One Earth Solar Farm

Applicants Response to Deadline 7 Submissions

Document Ref: EN010159/APP/9.48

December 2025

Drawing Title:
Surface Water Drainage Strategy
Western BESS Compound

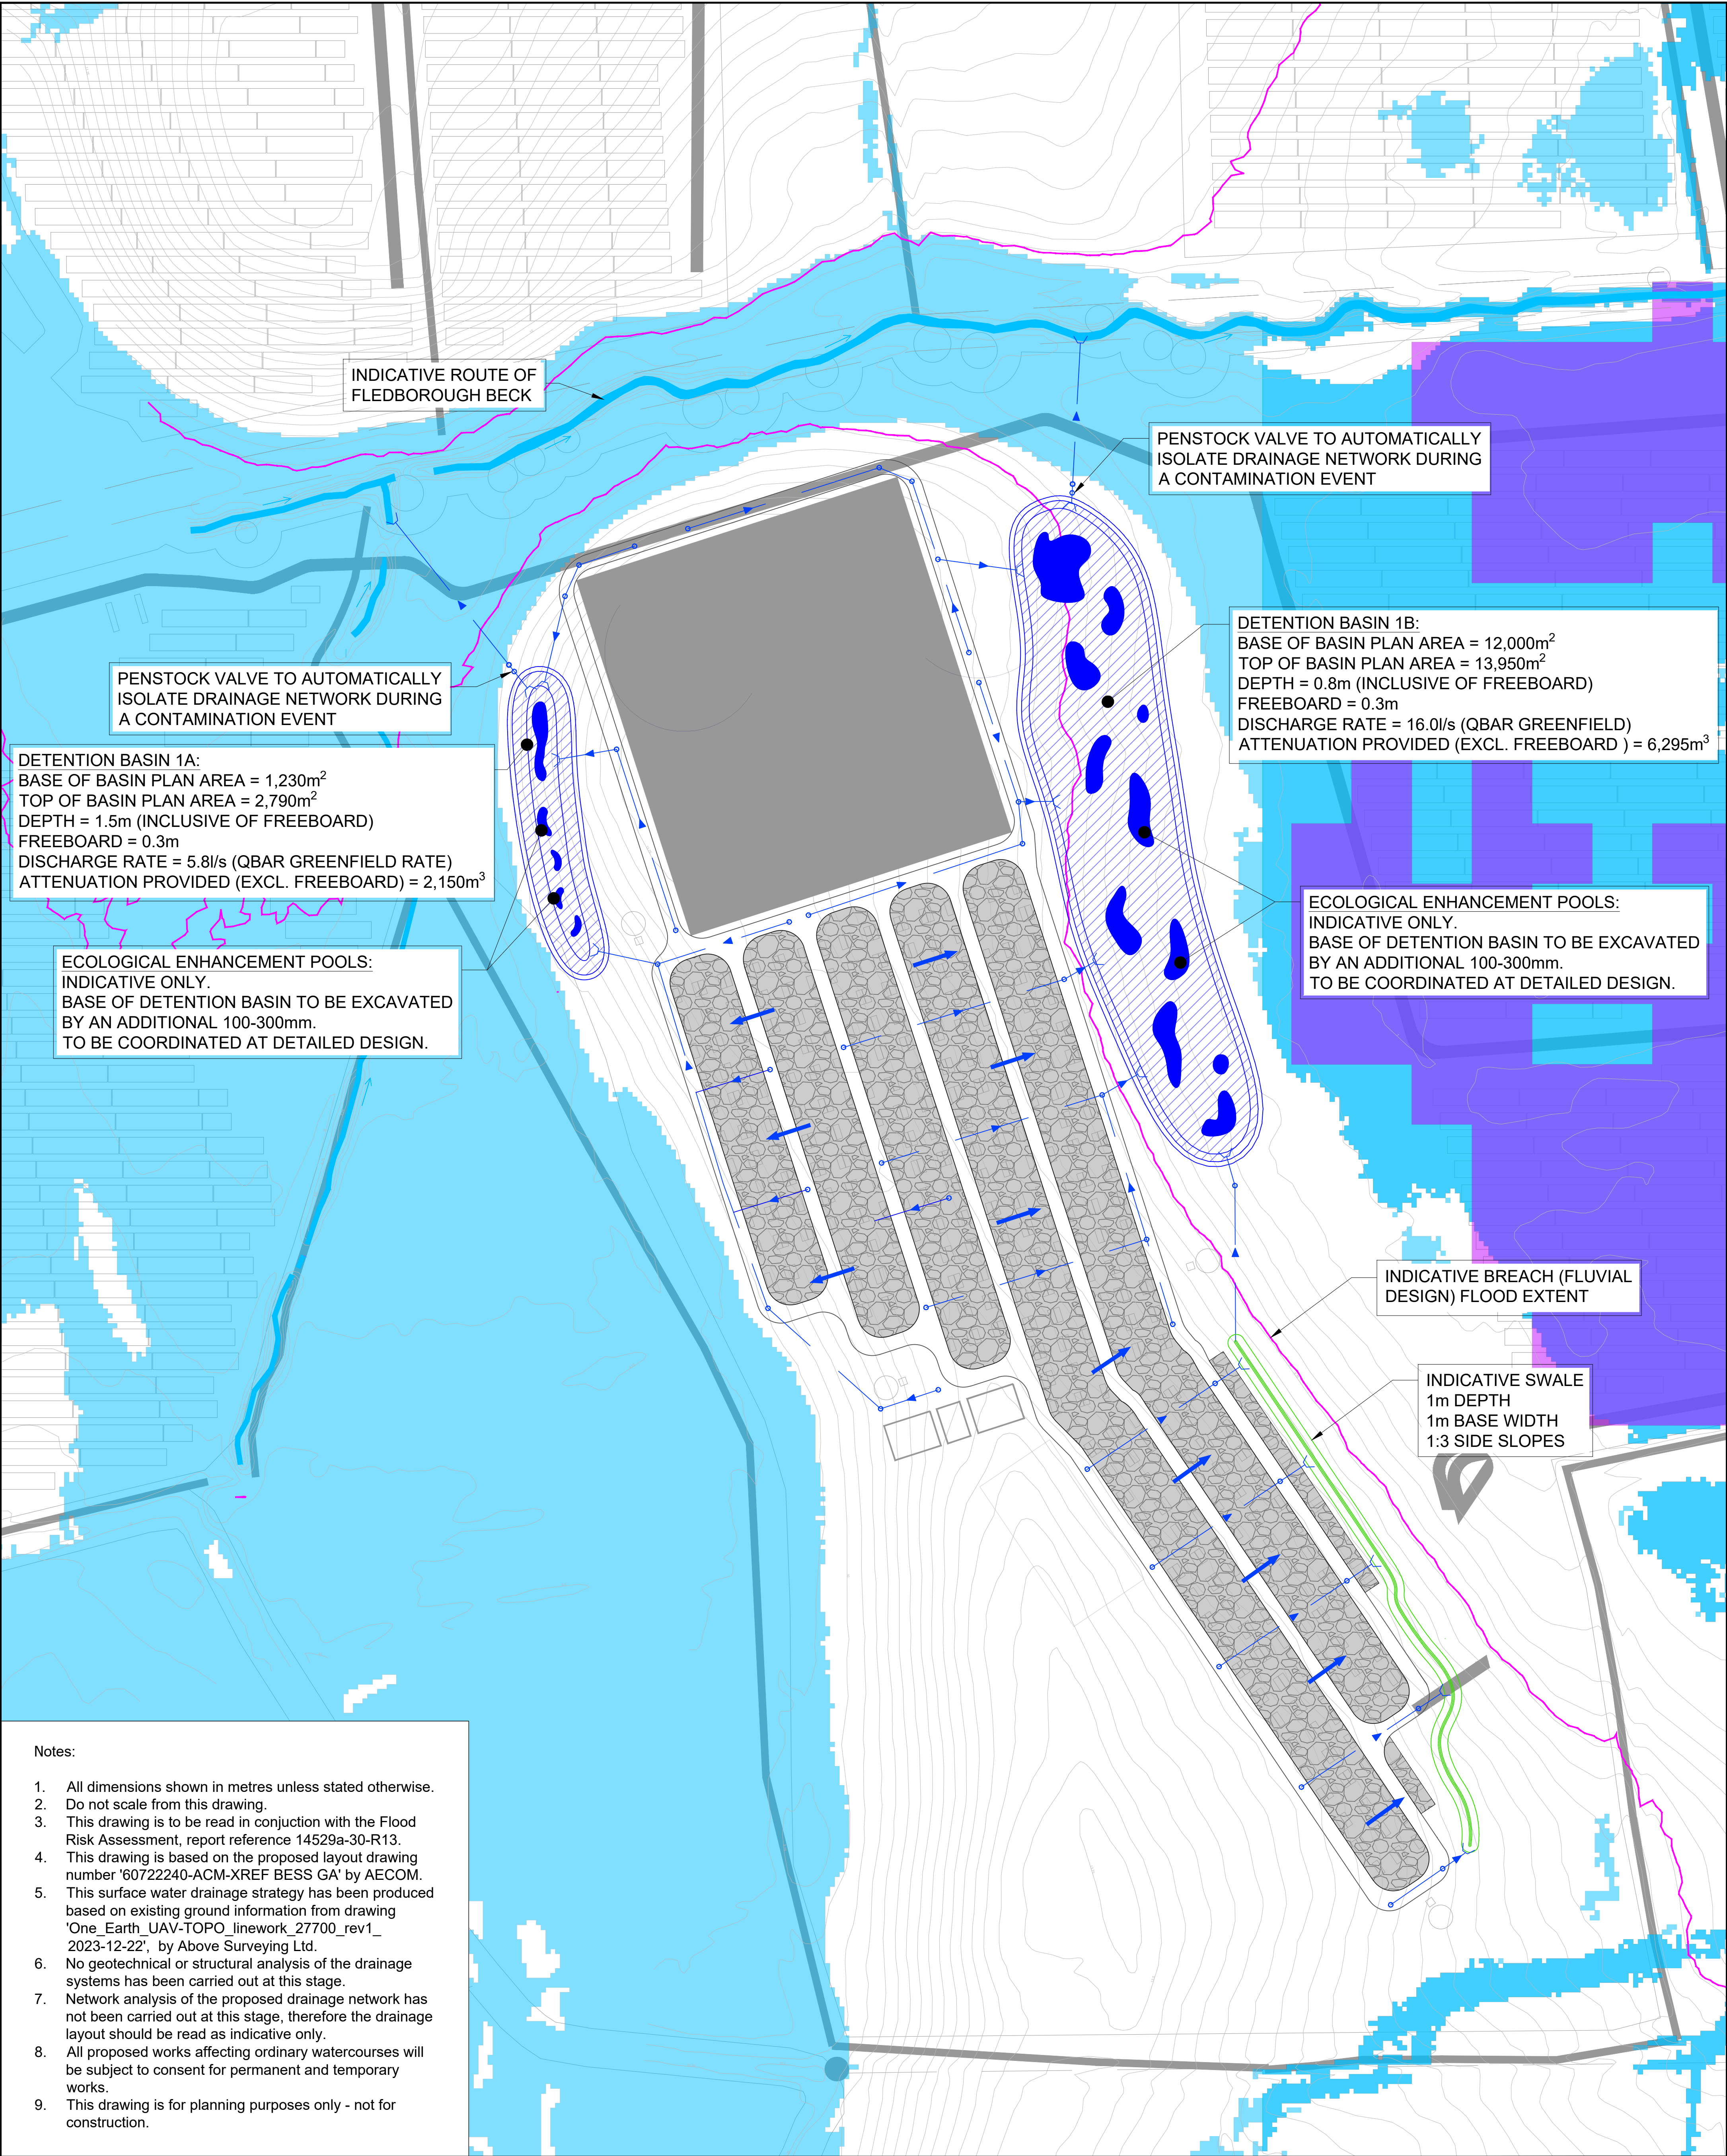
App Ref	Document Ref	Summary	Applicant Response
		<p>already be filling with heavy rainfall from the storm causing the flood) will overtop. The toxic fire water (containing Hydrofluoric Acid (HF) and heavy metals like Cobalt and Nickel) will spill directly into the floodwaters of the River Trent.</p> <ul style="list-style-type: none"> Conclusion: The "tankering" strategy is viable only in fair weather. It is a single point of failure in a flood scenario. The EA should require on-site containment capacity sufficient to hold 24 hours of fire water plus the 1-in100-year storm volume, with a "gravity-fed" capability that does not rely on road access. 	
D7R7	Mr Fox Written Submission 1	<p>The Jacobs 2023 Tidal Trent Model predicts flood level increases of 3.5mm on the eastern floodplain and 2.2mm on the western floodplain.^[^11] The Applicant argues these values should not be summed (to 5.7mm) because the floodplains act as "distinct cells."</p>	<p>The 5mm tolerance and separation of the East and West cells has been explained by both the Applicant and the Environment Agency on multiple previous submissions most recently in REP6-078 and REP6-056.</p> <p>Even if we were to look at the combined modelled flood volume lost for the east and west, to get the flood level change, this would need to be divided through by the design flood extent for both the east and west (within the Order Limits). This would result in an increase in 2.9mm which remains within the 5mm tolerance.</p>
